DECISION DELEGATED TO HEAD OF PLANNING

Application No: H16-0222-25 **Applicant:** Seagate Homes Ltd
Proposal: Details of foul water disposal & surface water disposal (Conditions 17 & 18 of H16-0136-23)
Location: Ivanda Nursery Monks House Lane Spalding
Terminal Date: 29th April 2025

12556 - WMS - ZZ - XX - D - C - 39202 - S8 - P7

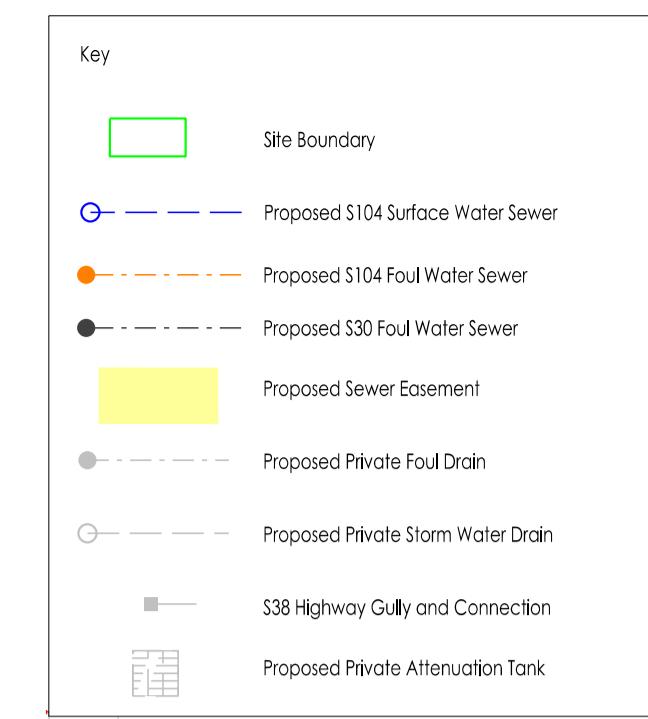
Drawing 12556-WMS-ZZ-XX-D-C-39202-S8-P7 shows connection to foul sewer public manhole 1702 this is acceptable to Anglian Water we can recommend discharge of condition 17.

Drawing 12556-WMS-ZZ-XX-D-C-39202-S8-P7 shows discharge of surface water to a watercourse is outside of Anglian Water's jurisdiction for comment.

The foul water disposal method will be subject to Anglian Water's approval process but because the route involves passing underneath the Board's drain an application for a relaxation of the 9m bylaw will need to be submitted and granted prior to installation.
